**RE: Sonata Unit 4 Trails Apartments  
Tracts 1, 2, and 3, The Trails Unit 4  
Third DRB Submittal**

RESPEC, agent for Sonata Trails, LLC, owner of the above referenced property, is requesting approval from the Development Review Board (DRB) on this Site Development Plan submitted for your consideration. This is the second submittal to the DRB for this project. The first hearing was held on June 3, 2020. Below is a response to comments received at the first DRB meeting.

SHEET TITLE:  
**CONCEPTUAL SITE PLAN**

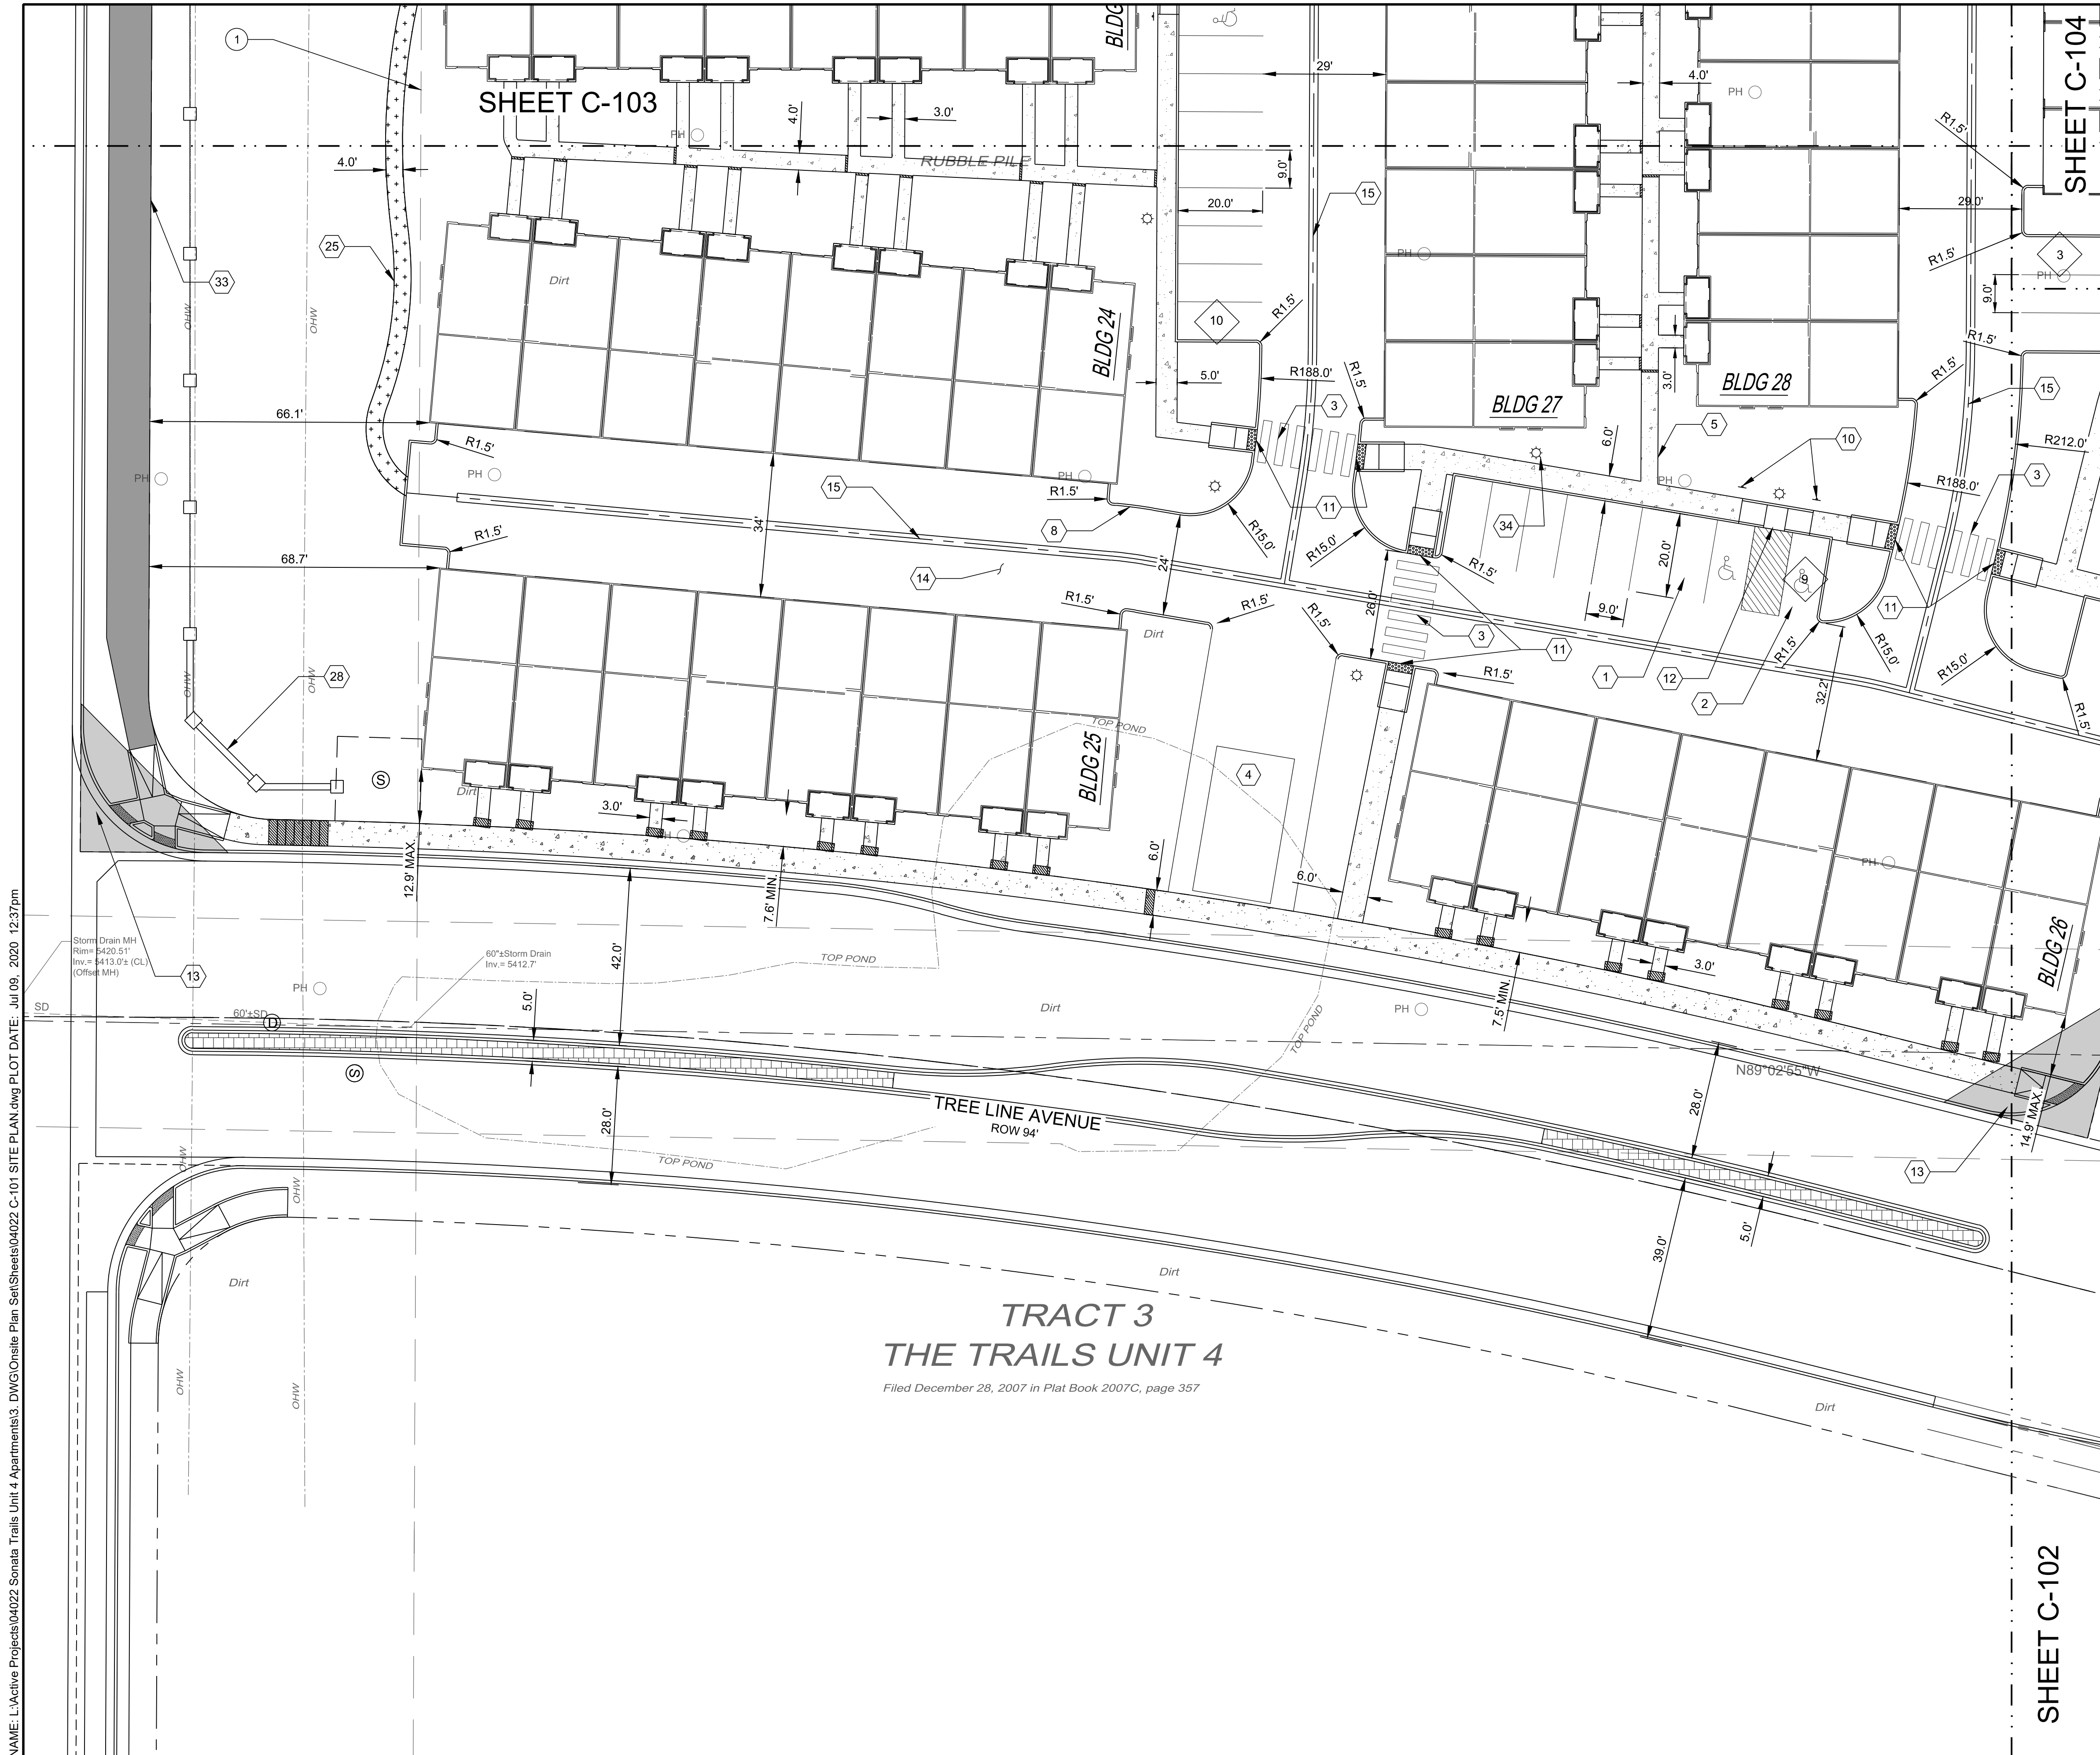
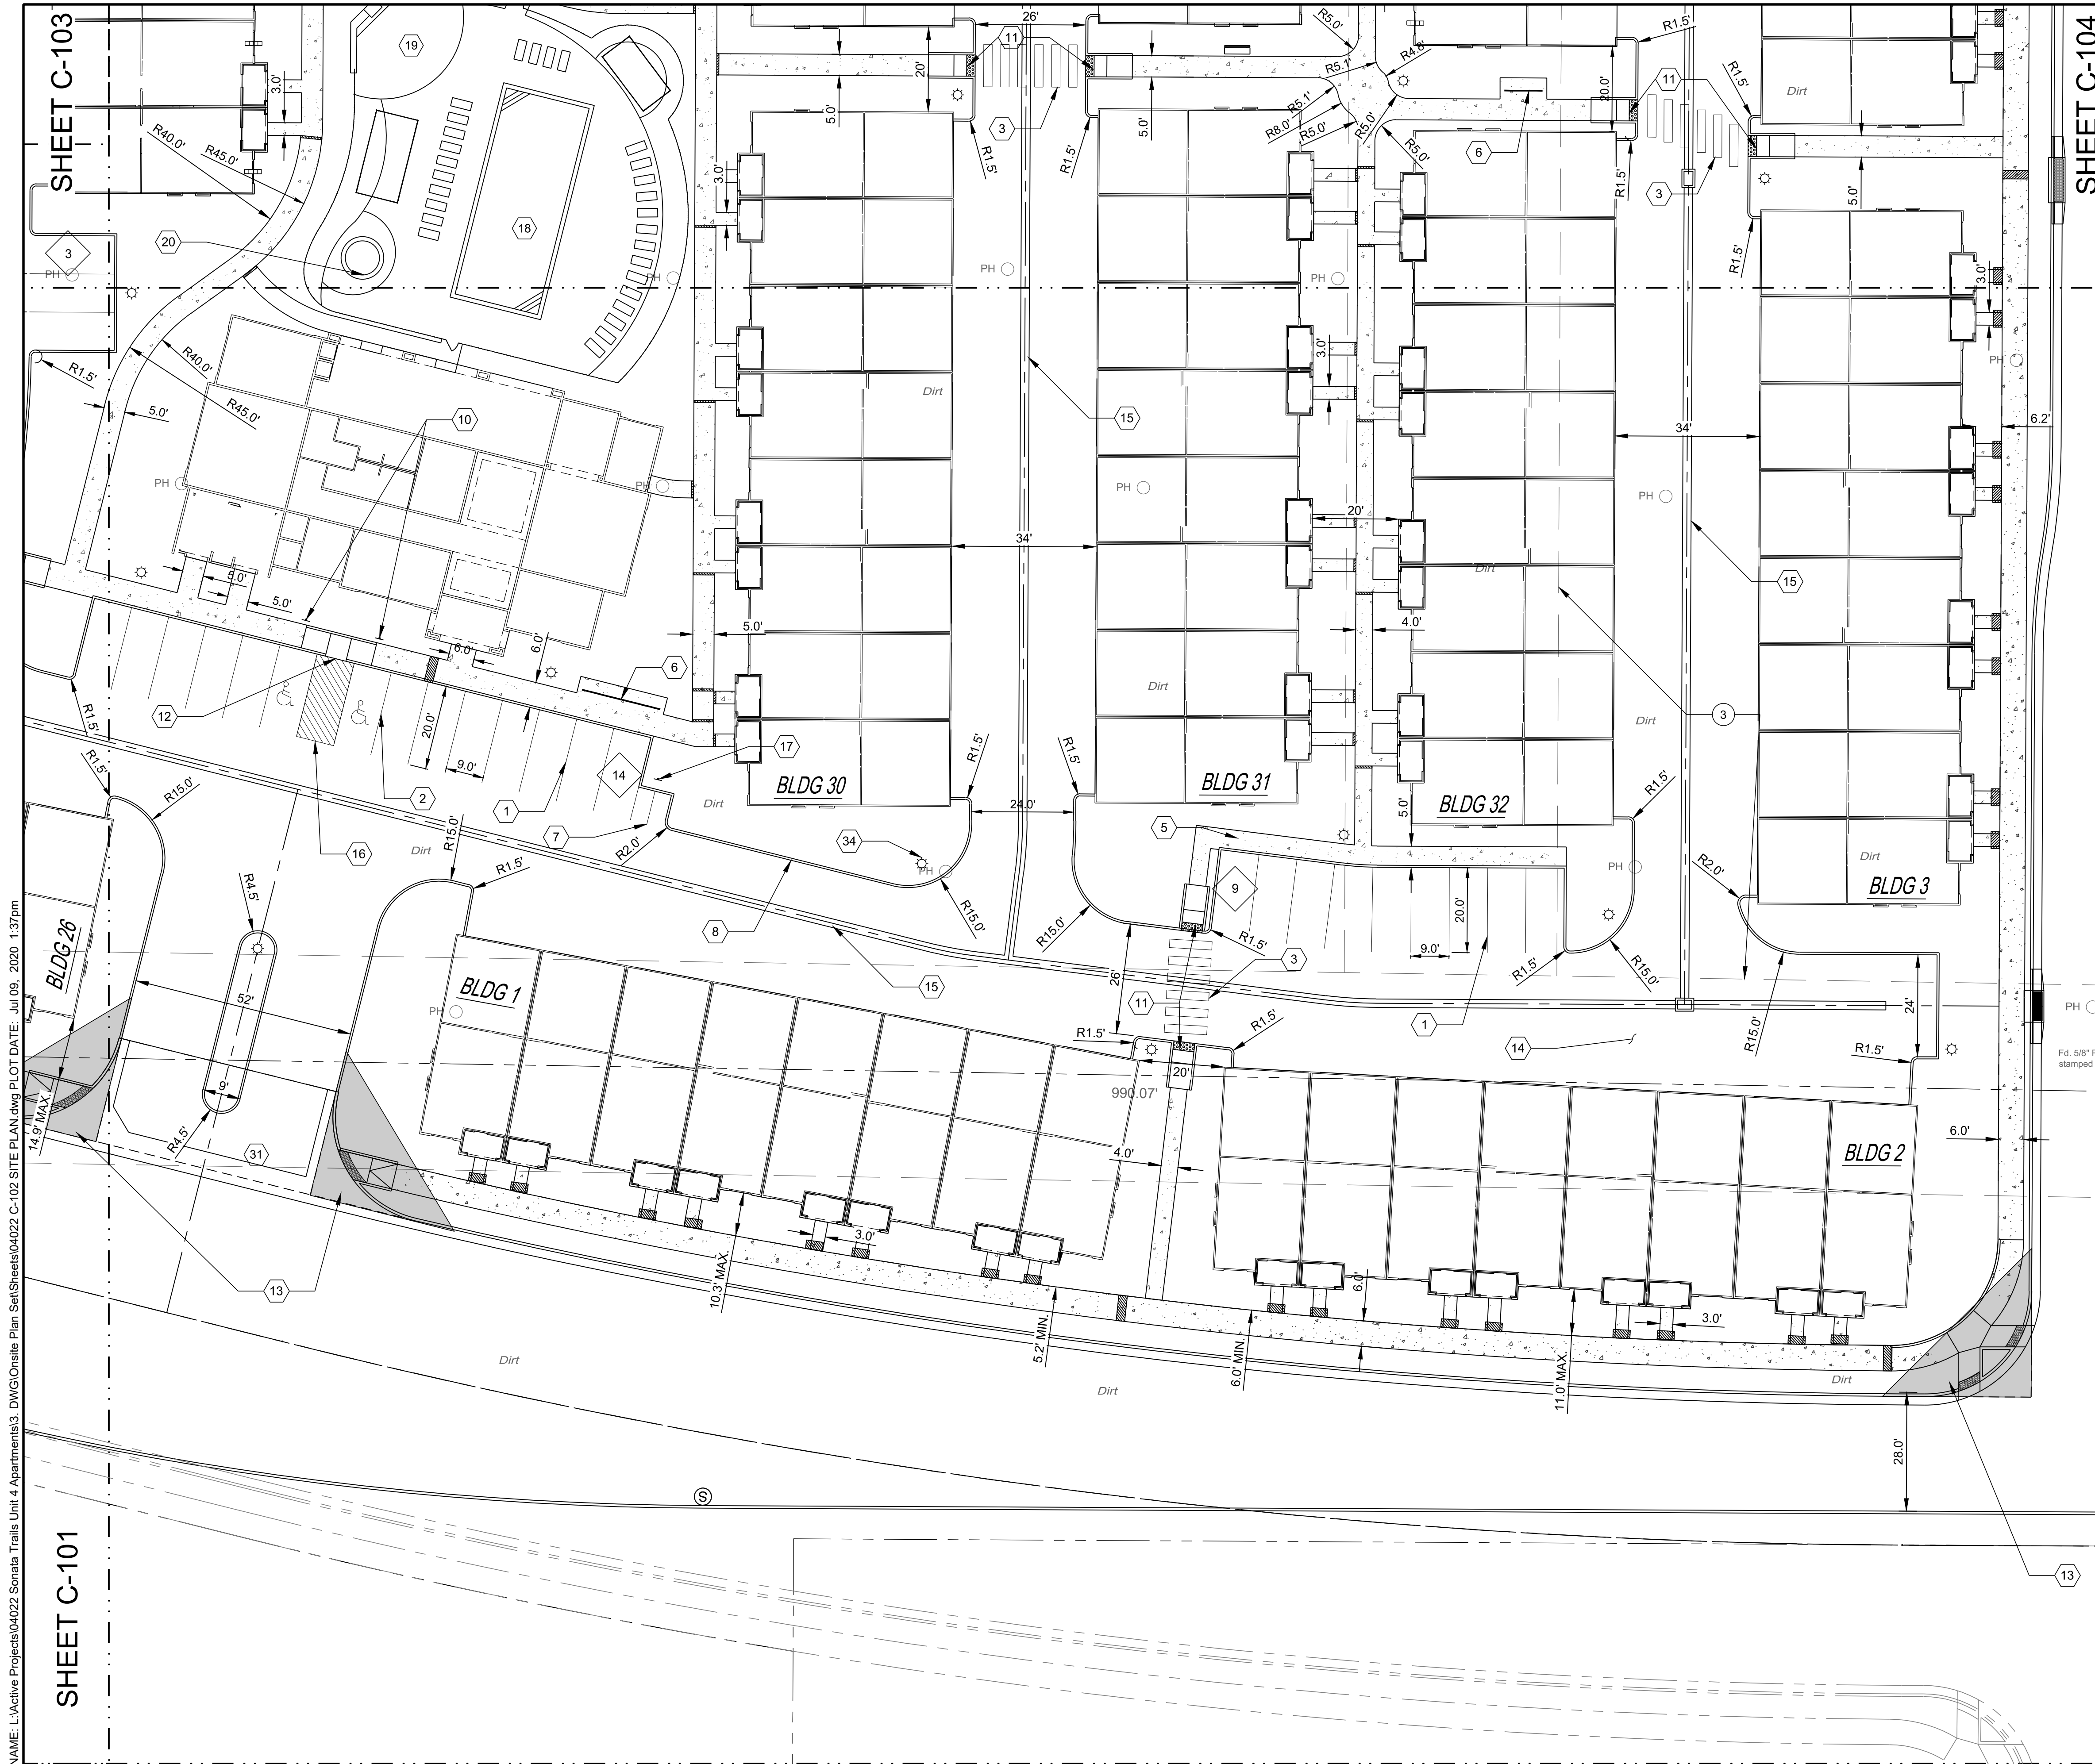
3. Show Oak Ridge limits on infrastructure list. Because roadway improvements are required along the entire length of the site, Chatsworth construction limits should end at Oak Ridge.  
/ Oak Ridge and Chatsworth added to infrastructure list. See revised infrastructure list.

4. Add keyed notes for all ADA ramps on the site plan.  
/ Keyed notes added for all ADA ramps. See revised site plan sheets.
5. Provide motorcycle parking sign detail.  
/ Motorcycle parking sign detail provided. See revised detail sheets.

6. A 6-foot minimum sidewalk width shall be provided from main building to right-of-way and from handicapped spaces at main building to building entrance. (The width shown is 5 feet.)  
/ The 6' ADA path provided is at the western-most sidewalk connection to Tree Line Ave, then heads north across the drive aisle and turns east until reaching the clubhouse building.

7. Add a keyed note for crosswalks on the site plan.  
/ Crosswalk keyed note provided. See revised site plan sheets.

8. Add a keyed note for clear sight triangles on both landscaping and site plan.  
/ Keyed note for clear sight triangles provided. Also added at public intersections. See revised landscape and site plan sheets.
9. Dimension all parking spaces. All curb radii need to be labeled.  
/ All parking spaces and curb radii have been dimensioned and labeled. See revised site plan sheets.
10. Provide roadway cross-section for Woodmont prior to second phase of development.  
/ Acknowledged. A roadway cross-section for Woodmont will be provided when Tracts 3 and 4 to the south develop.

- In addition to seeing the plat and right-of-way dedication, he wants to know what the ultimate design will look like both at the Treeline intersection and at the Oak Ridge intersection even though you are expected to just build your half. He wants a clear picture of right-of-way dedication and making sure that it is workable. He wants to know what you are dedicating and what is proposed for dedication for other future developers.  
/ Future roadway linework added for clarity on right-of-way dedication. See revised site plan sheets.

- I believe on Treeline, he was unclear about the design. It might help to just show that temporary transition length when you go from a full road section to a half road section.  
/ Temporary transition length from full to half section labeled. See revised site plan sheets.
